From:
Sent: 28 June 2024 17:39
To: Nick Hirst
Cc: DCAdmin
Subject: Planning Application 2024-91236 - Poor Design
Attachments: landing_window_contradiction.pdf

The plans, for plots 34 and 35, show a window, at the top of the landing, on the second floor.

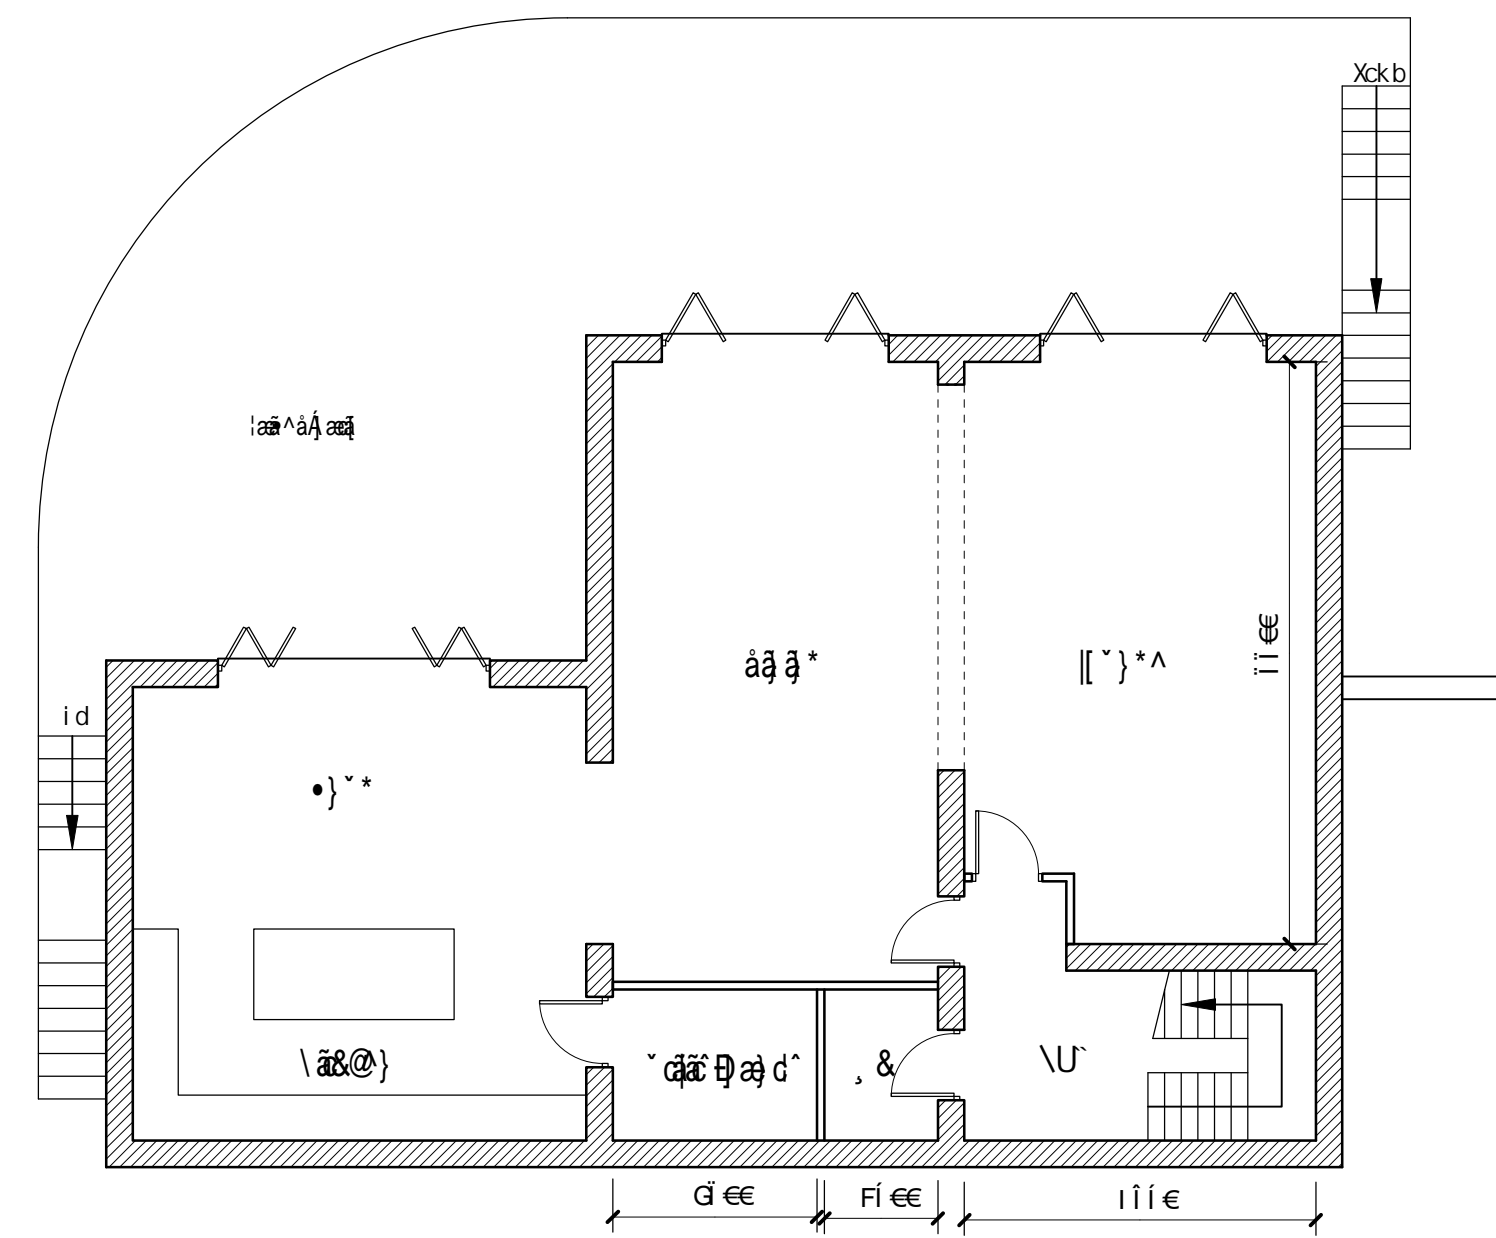
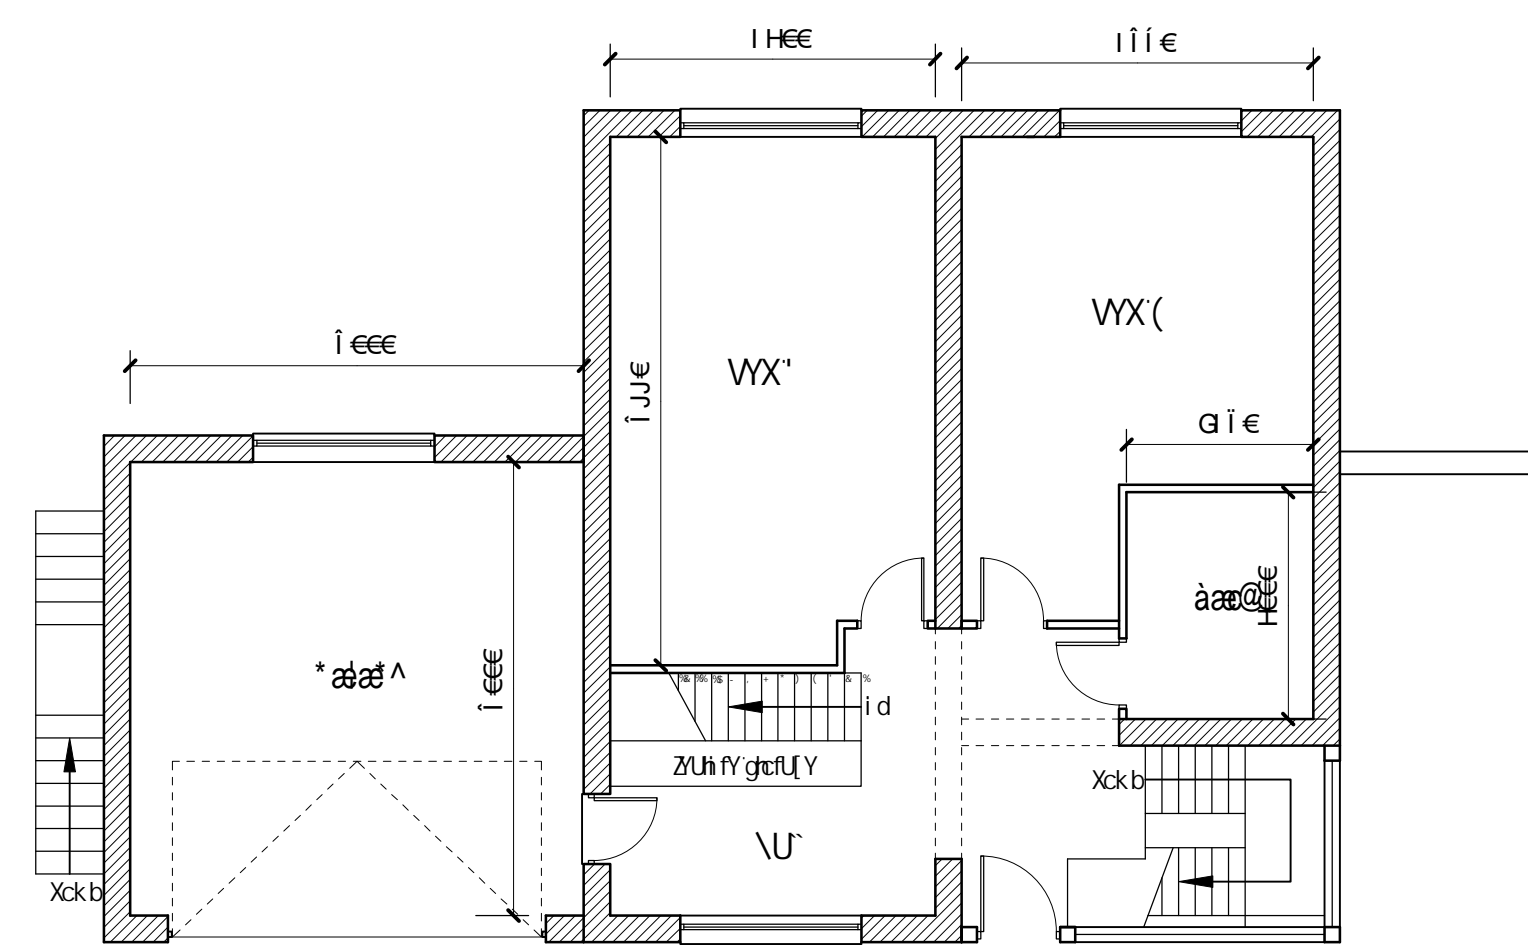
The image, right, shows the window highlighted.

The image below, which shows the same side elevation, shows no such window.

In this case, the contradiction is seen on the same page.

Is the window being applied for, or not?

And, if it is, what are the proposed dimensions?

Is the glass obscured?

Would the window open, or not?
